**2020/0615**

Variation of condition 1 of application 2020/0510 (Residential development of 5no. detached bungalows) to allow variation in bungalow design for plot 3

Land to the north of Lane End Mews, Off High Street, Thurnscoe, Rotherham

SITE PLAN

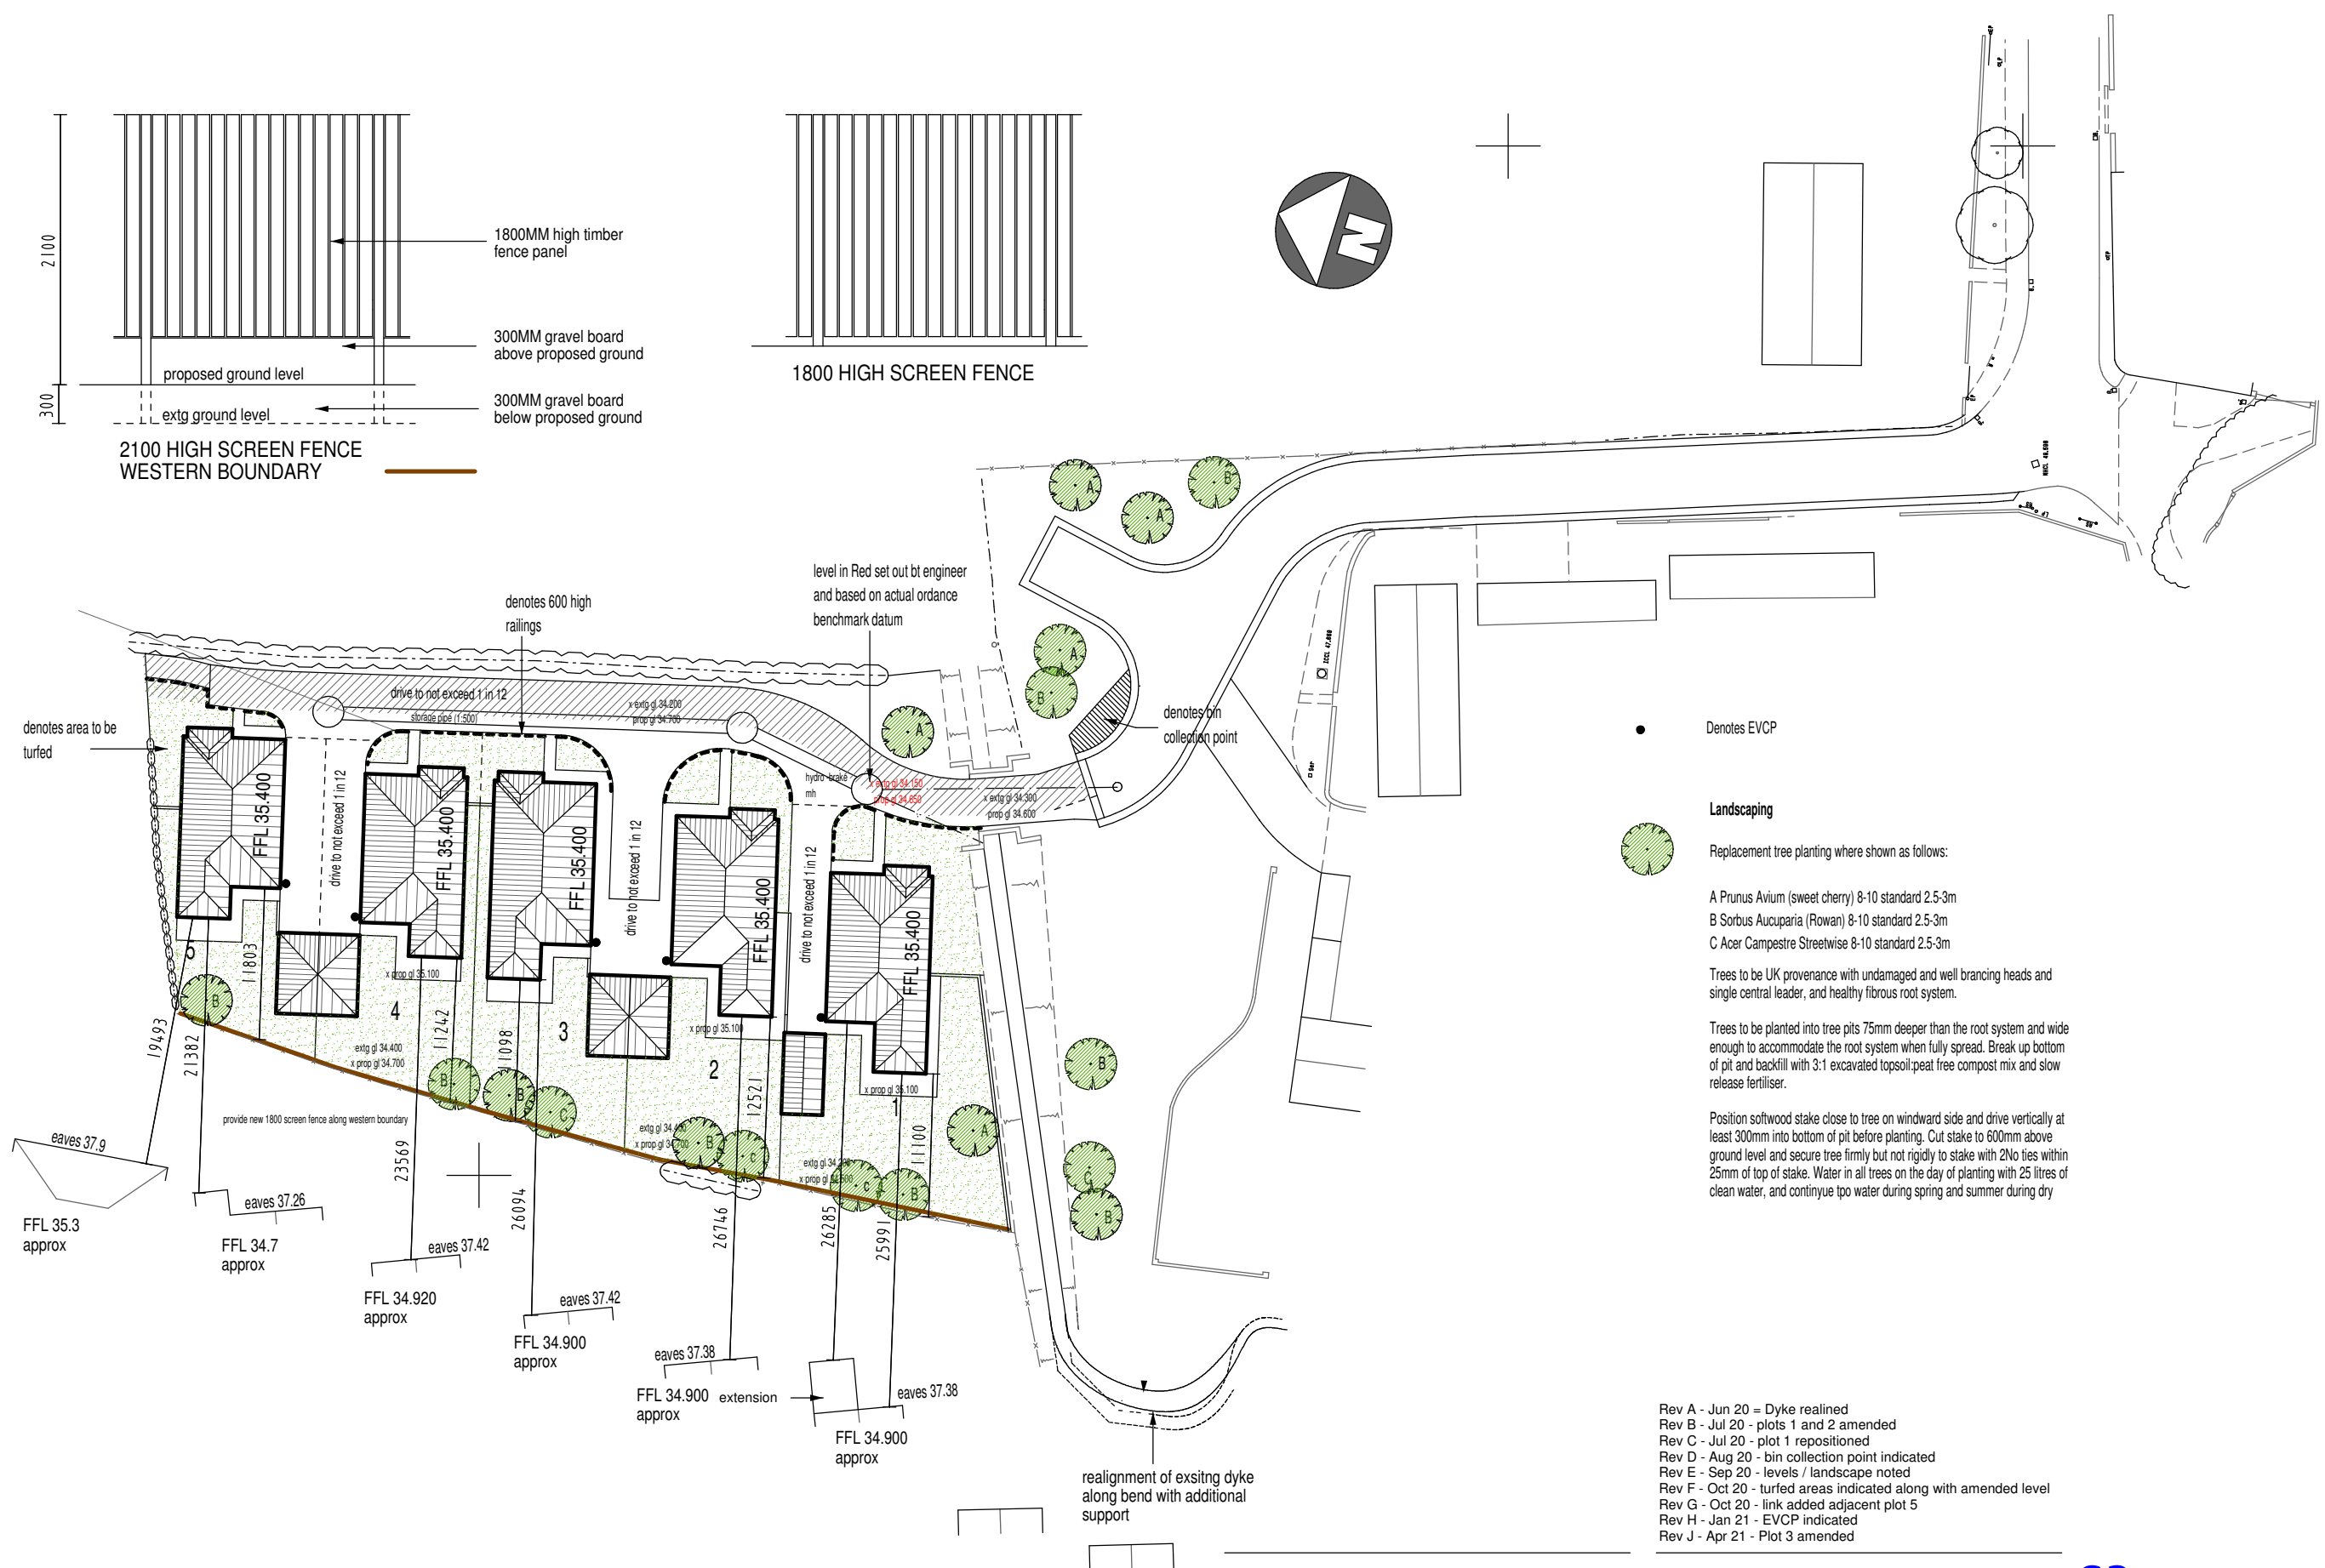
Increase in length of the bungalow from 14.06m to 15.36m and 11.56 to 12.56m to allow for a utility room and extended bedrooms. An additional door is proposed to the utility room on the side elevation and 1 new rooflight. A comparison of the plans can be seen below. The site plan is amended accordingly and the separation distance from the property to the rear is

amended from 27.394m to 26.094m and 12.398m to 11.098m which amounts to approx. 1.3m. The height of the dwelling remains the same.

PROPOSED BUNGLOW Plot 3

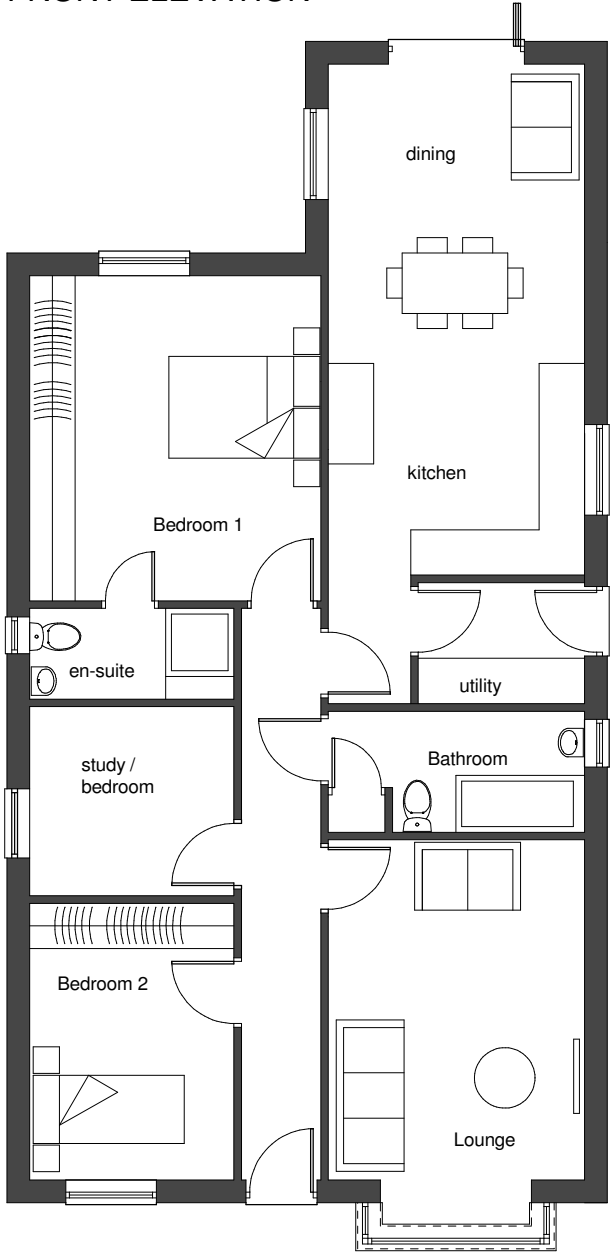
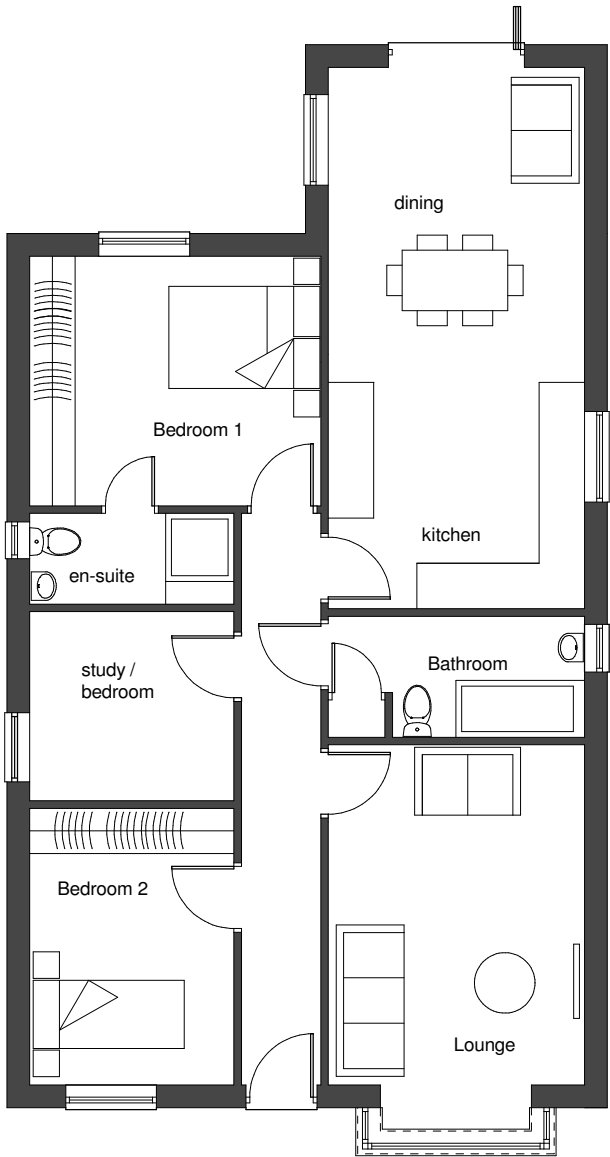
The change to plot 3 results in a slightly larger dwelling to allow for a small utility room and the addition of a door and rooflight. The additional door and rooflight would not cause any significant overlooking of the adjacent properties as a utility room is not a habitable room. The change results in the dwelling being set some 1.3m closer to the properties at the rear, however the rear elevation of the plot is still in excess of 21m from the habitable windows of these properties which is in line with the SPD Guidance. There should be no significant impact to the adjacent dwelling due to this small change. The internal arrangements would still meet the requirements of SPD.

The small change to the size of the dwelling is considered acceptable and the property is not excessive in size or scale. The only other external changes include a small rooflight and door which are acceptable in terms of design. The amended proposal is in compliance with Local Plan Policy D1 and SPD: Design of Housing Development and is acceptable in terms of visual amenity.
